# CITY OF ALBUQUERQUE

February 13, 2018

**RE: Broadstone Highlands Hotel Block  
Conceptual Grading and Drainage Plan  
Engineer's Stamp Date: 2/12/18  
Hydrology File: K15D034B**

Re: Highlands Hotel / Hydrology File K15D034B

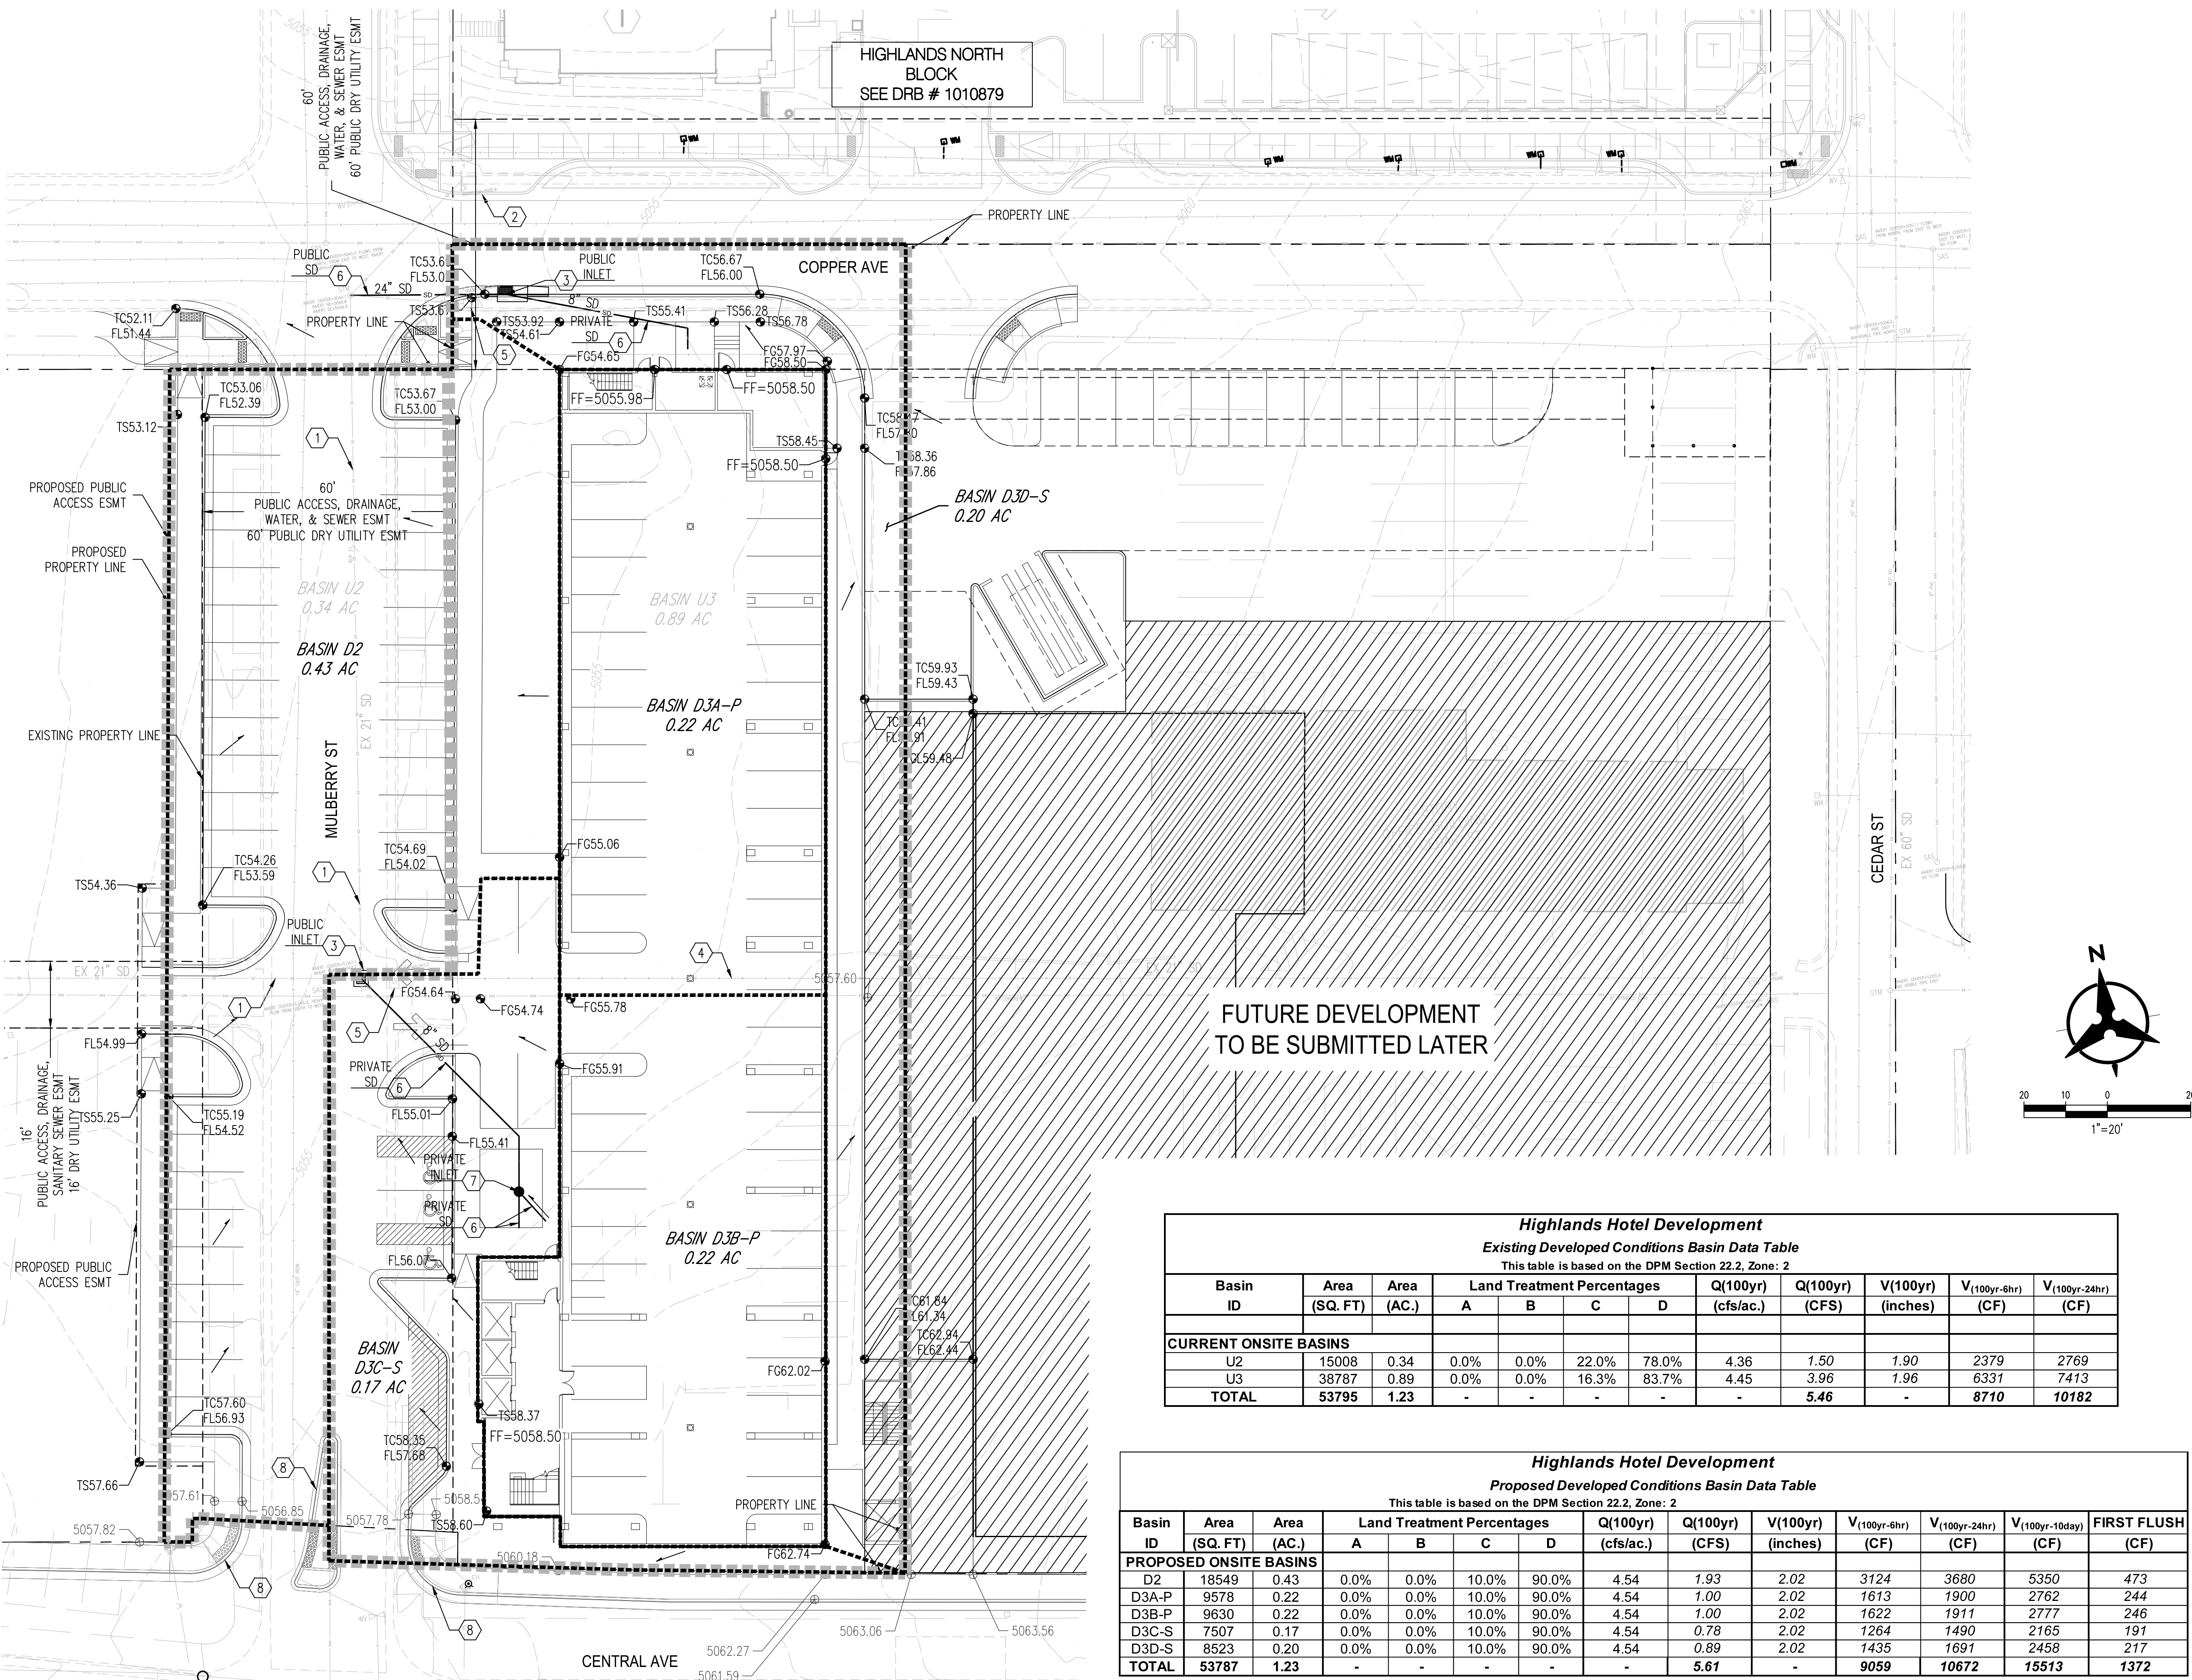
Prior to Building Permit a detailed Grading and Drainage Plan will be required. This plan will need to callout the two inlet replacements as private infrastructure (not public); additional comments can also be reasonably expected.

1. At the intersection of vacated Mulberry and the alley, provide a clearly defined waterblock, 1' high, to prevent flows from leaving Mulberry and flowing west down the alley.

2. Clarify the work to be performed on the public and private storm drain at the intersection of vacated Mulberry and the alley. Currently there is a public manhole in the street and a public type-D inlet in the flowline. Will the manhole be replaced with a new inlet, with the street graded towards it? The new inlet does not appear to be placed where it will intercept flows.

3. Provide additional flowline elevations at the intersection of vacated Mulberry and Central. Is there anything here to keep flows from entering your site from Central?

*Response: A water block will be provided at the intersection of Mulberry and the alley to prevent flows from heading west into the alley.*

*Response: The existing public manhole and public type-D inlet along the flowline which are currently there today are intended to remain. The inlet will be replaced in the same location with a new type-D inlet.*

*Response: Additional flowline elevations have been added along Mulberry and Central. No water block was provided with the construction of the returns with the ART project. The existing flow today heads north onto Mulberry.*
